Date: 02 March 2023
Our ref: 416936
Your ref: EN010127

NSIP Reference Name / Code: EN010127

Title: Natural England's comments in respect of Mallard Pass Solar Farm

Natural England's Relevant Representations

Z:\7863_NSIP_SOLAR_FARM_CONFIDENTIAL\CADDRAWINGS\7863_0190_0165_GI_STRATEGY.DWG

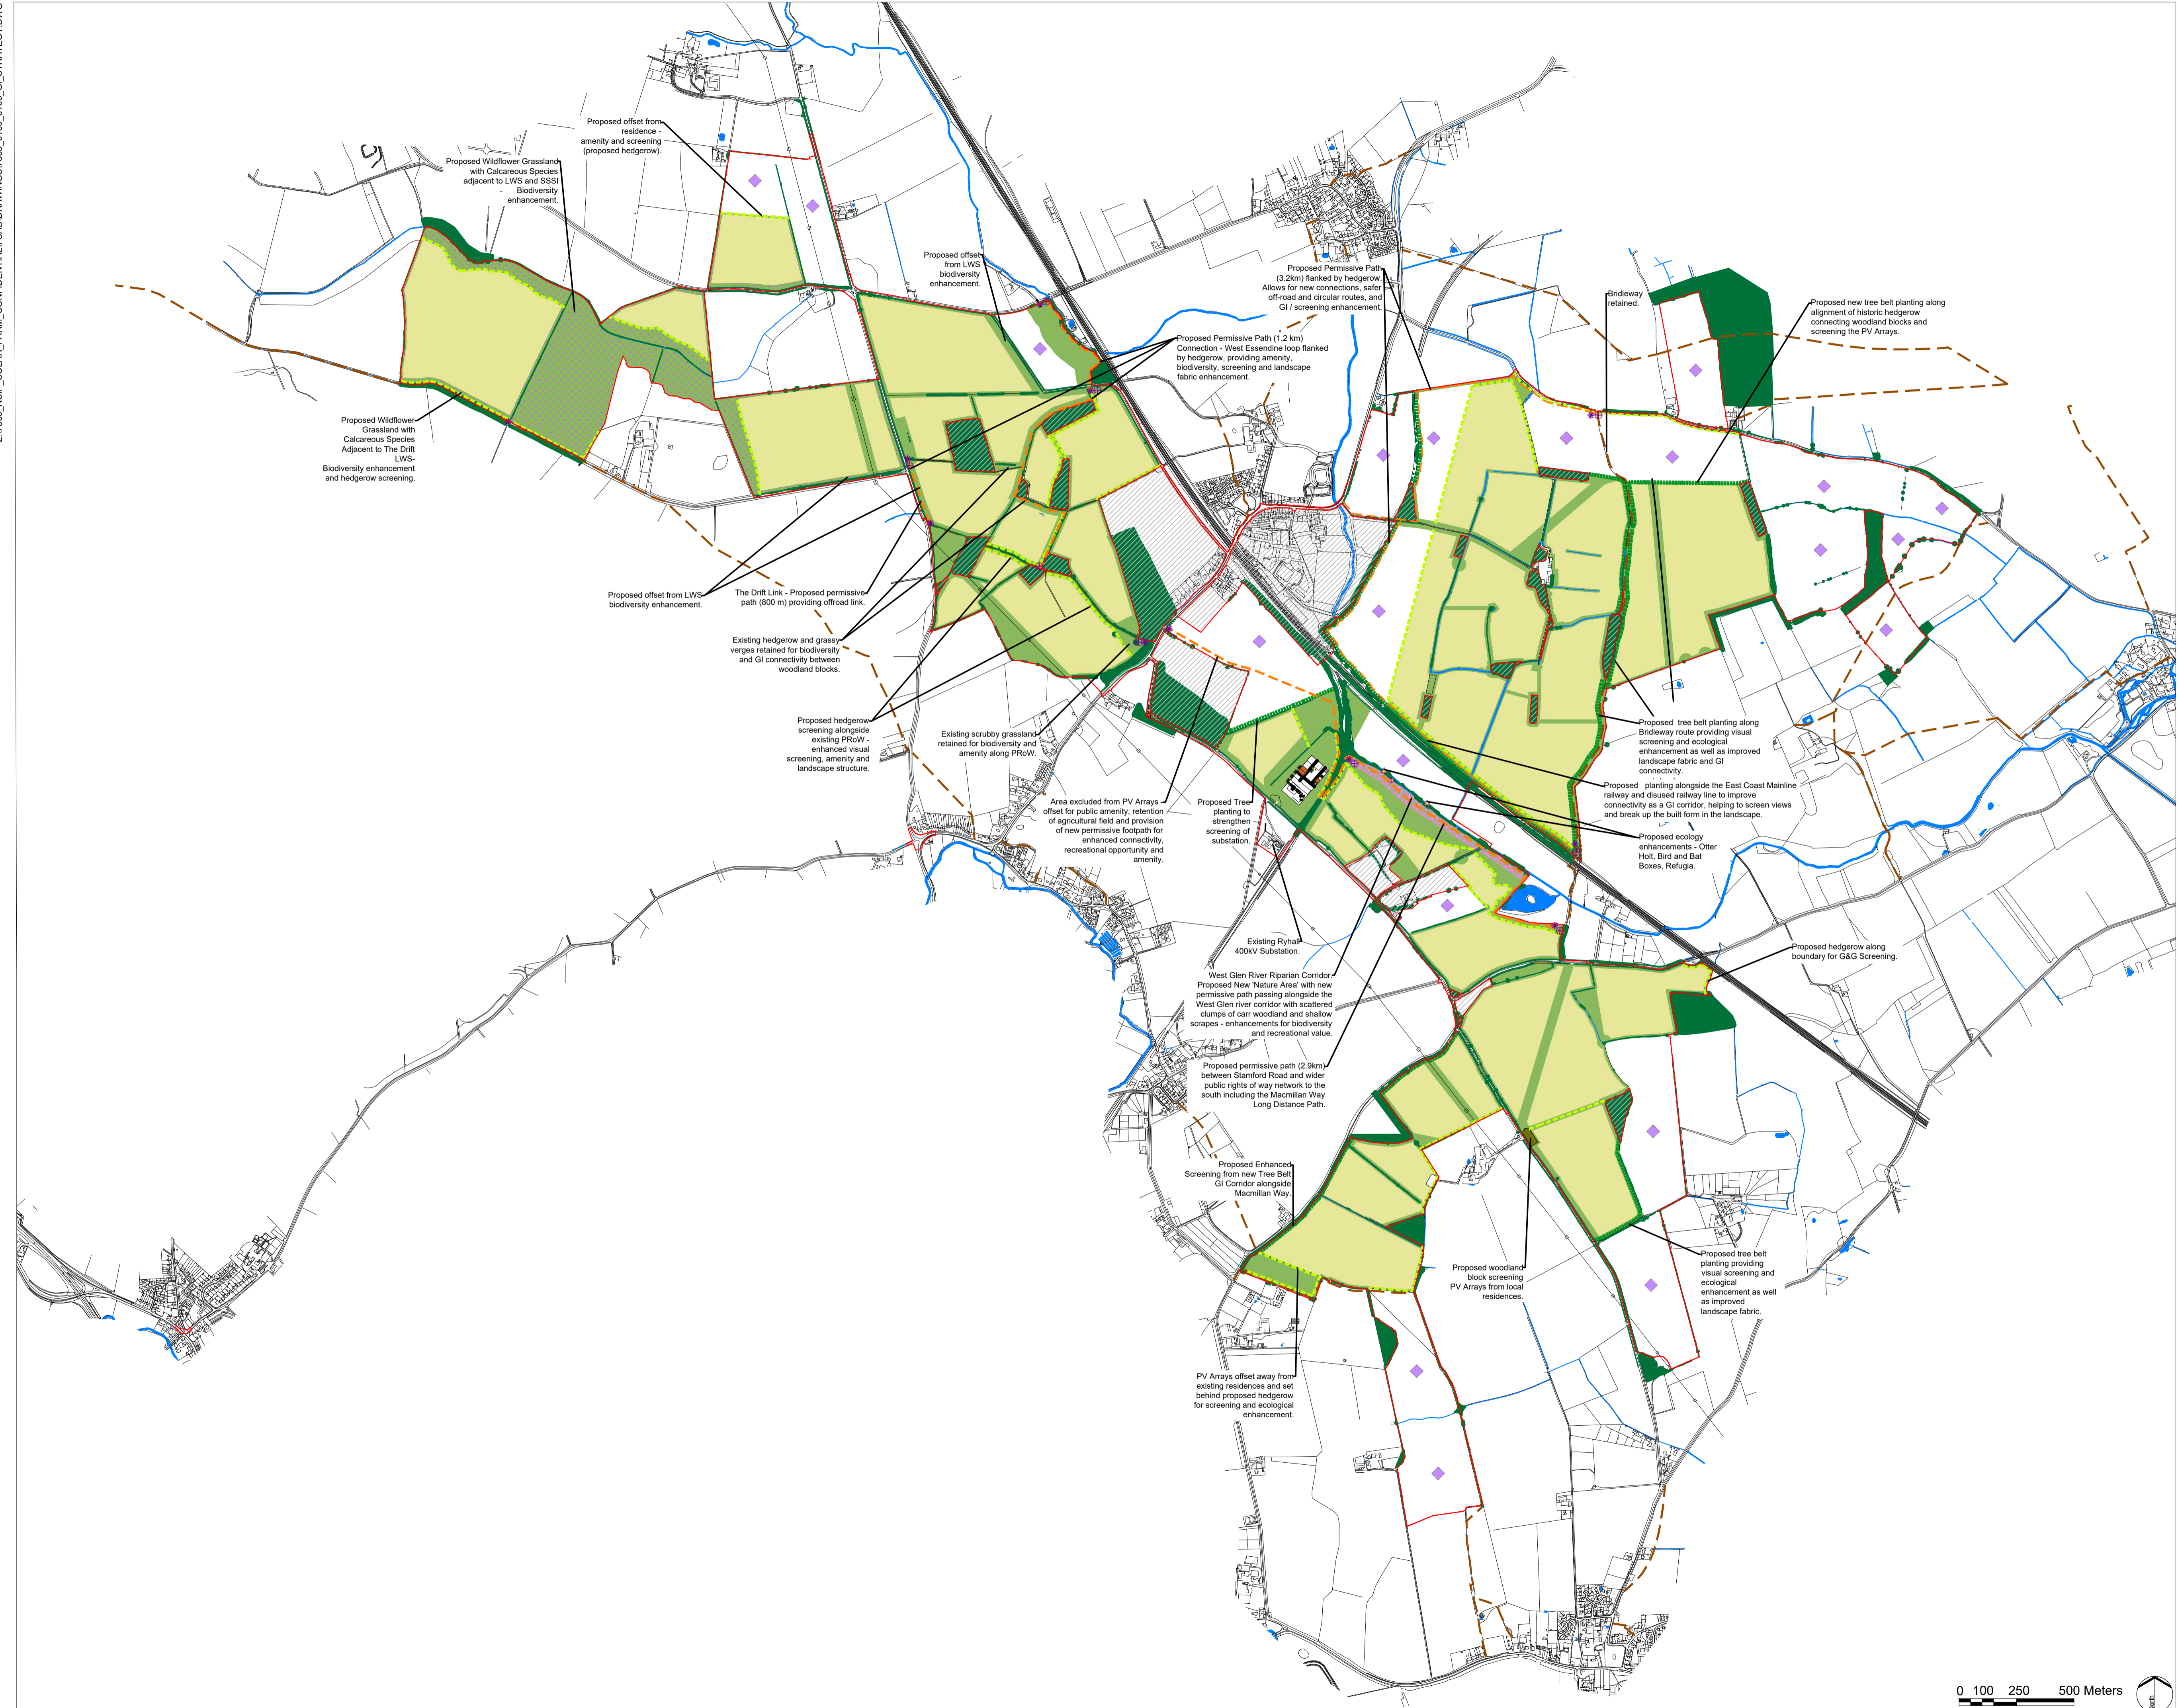
Figure 6.11 (Green Infrastructure Strategy Plan) provides an illustrative overview of the Green Infrastructure and enhancements that will come forward as part of the development. This includes a large enhancement area in the northwest of the site, and its management as calcareous grassland. This will complement the adjacent Ryhall Pastures and little Warren Verges SSSI, as well as increasing ecological connectivity between this SSSI and woodland to the north-west (including Newell Wood SSSI).

Figure 6.11 (Green Infrastructure Strategy Plan) provides an illustrative overview of the Green Infrastructure and enhancements that will come forward as part of the development. Natural England is generally supportive of the enhancements proposed and welcomes the management objectives set out within section 3 of the oLEMP.
